**Subject:** Planning consultation for application reference: 19/00963/OUT

Arboricultural Officer (north)

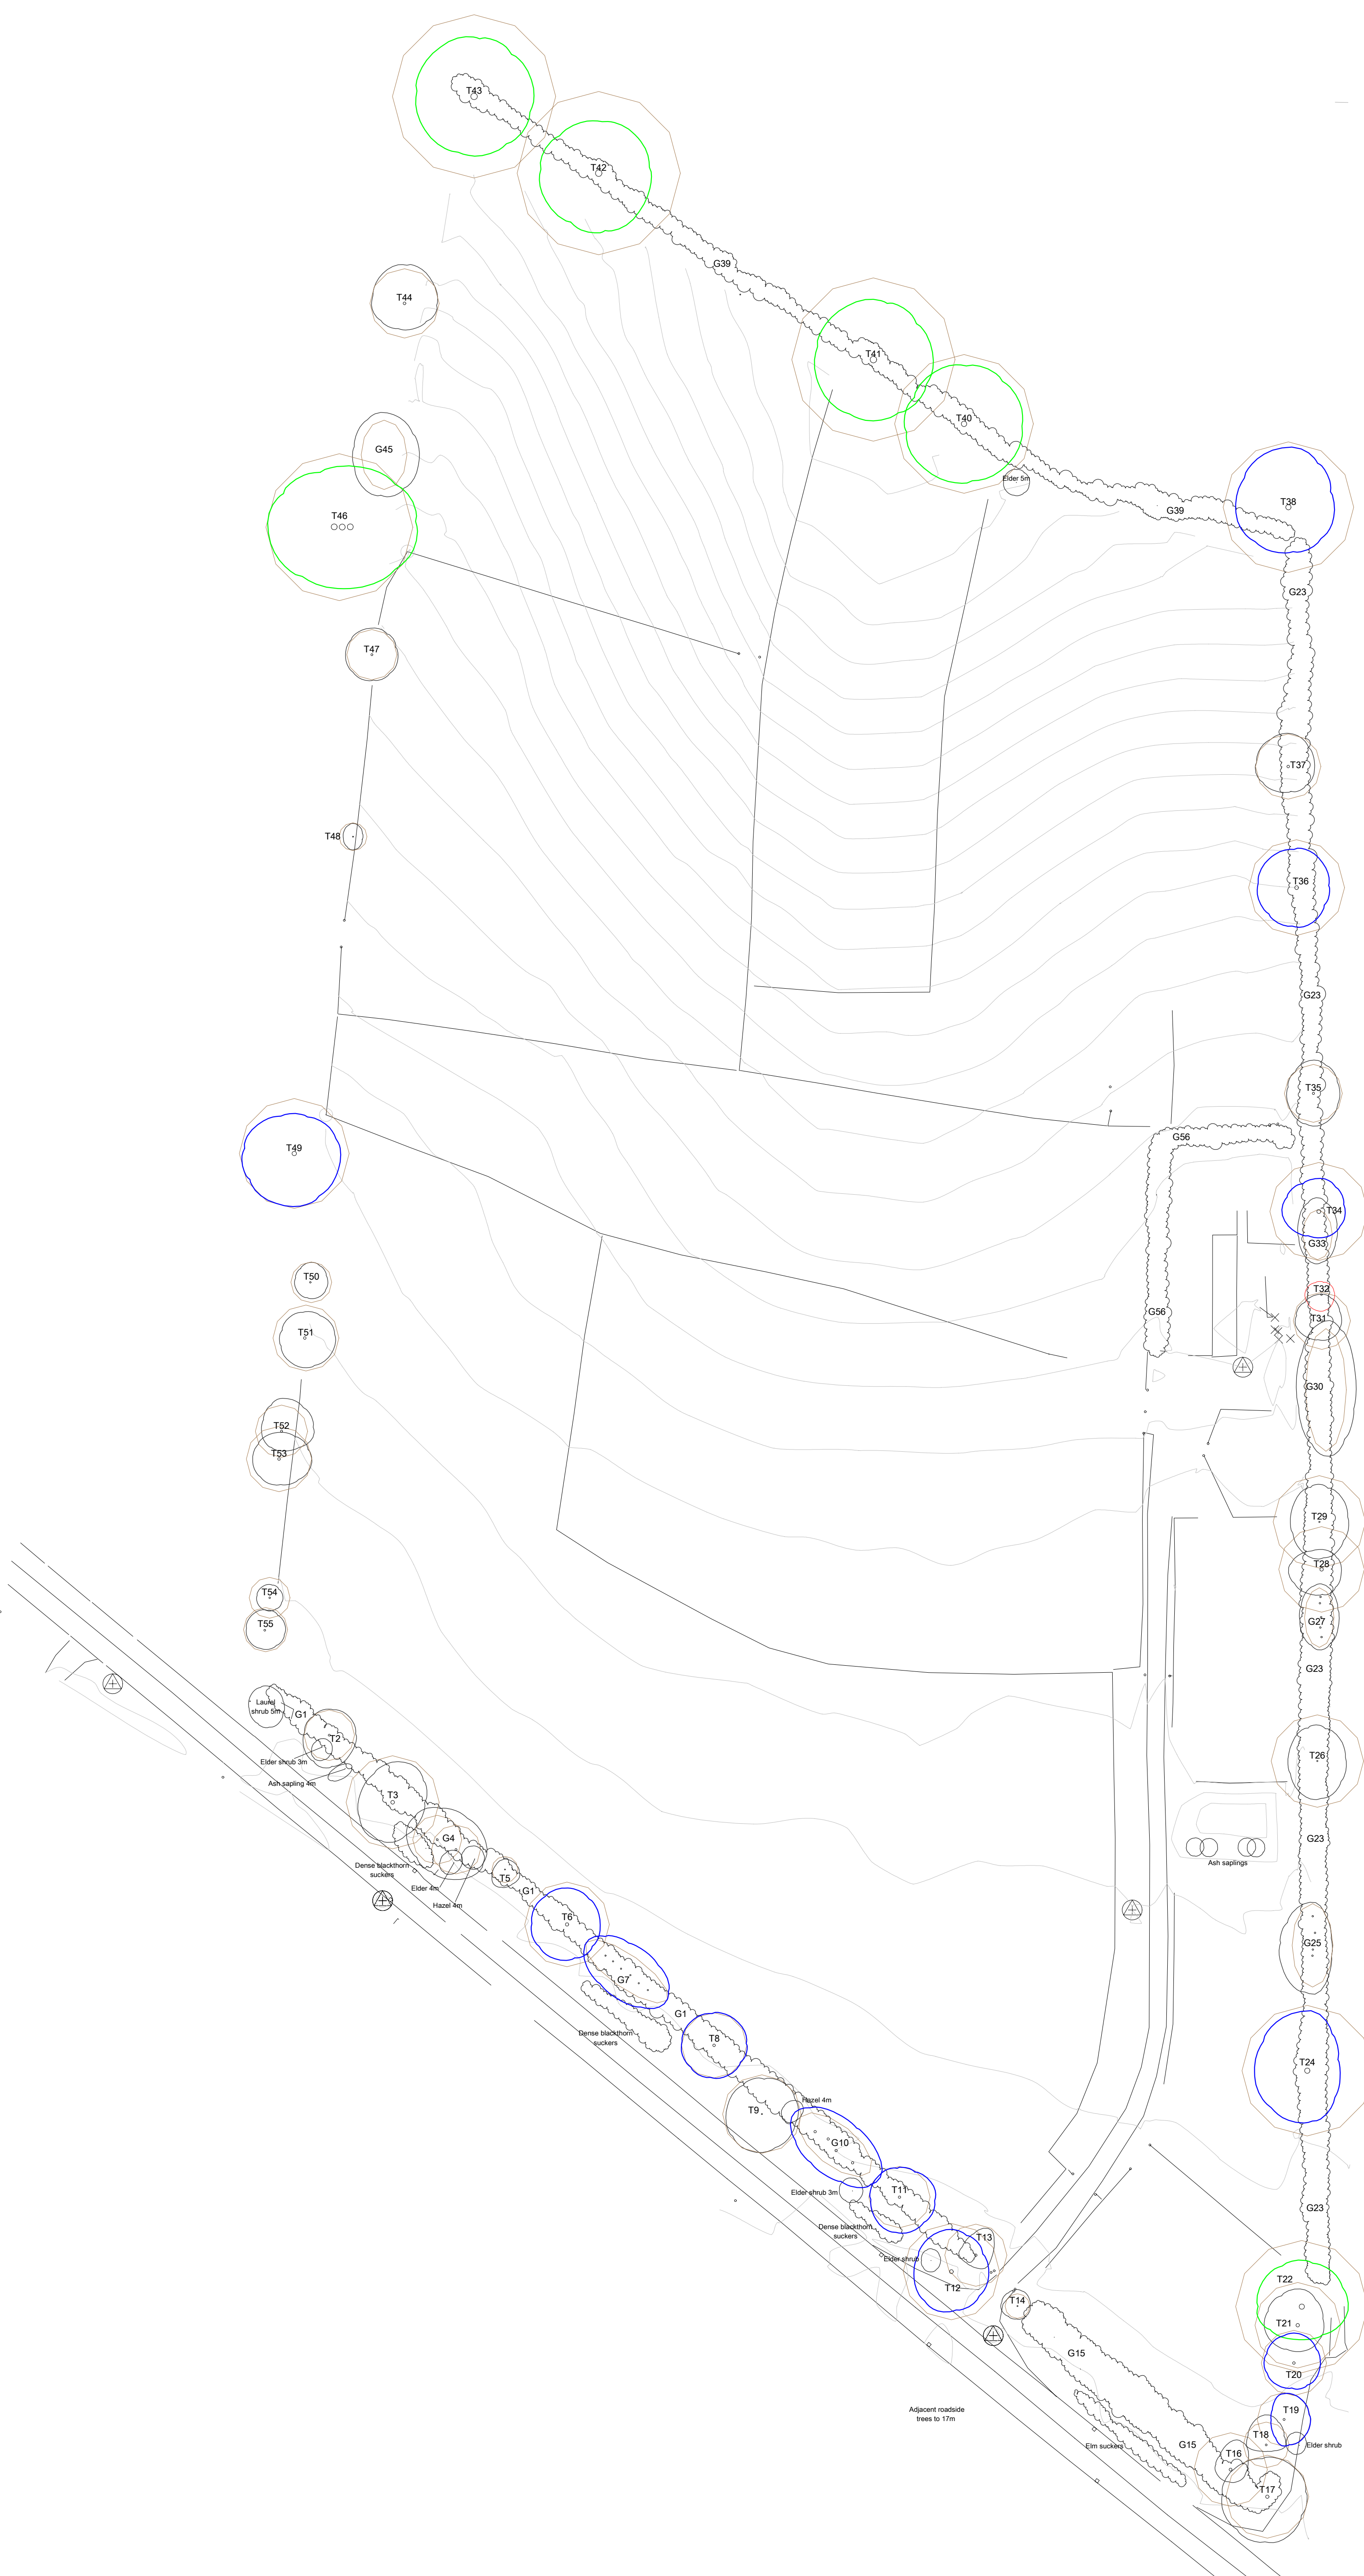
Looking at the outline plans the high category trees have been considered and are a suitable distance from the proposed development. The position of properties and associated hard standing should be considered in relation to the root protection areas and future conflict with buildings and gardens. In addition my comments of 10/07/19 still stand.
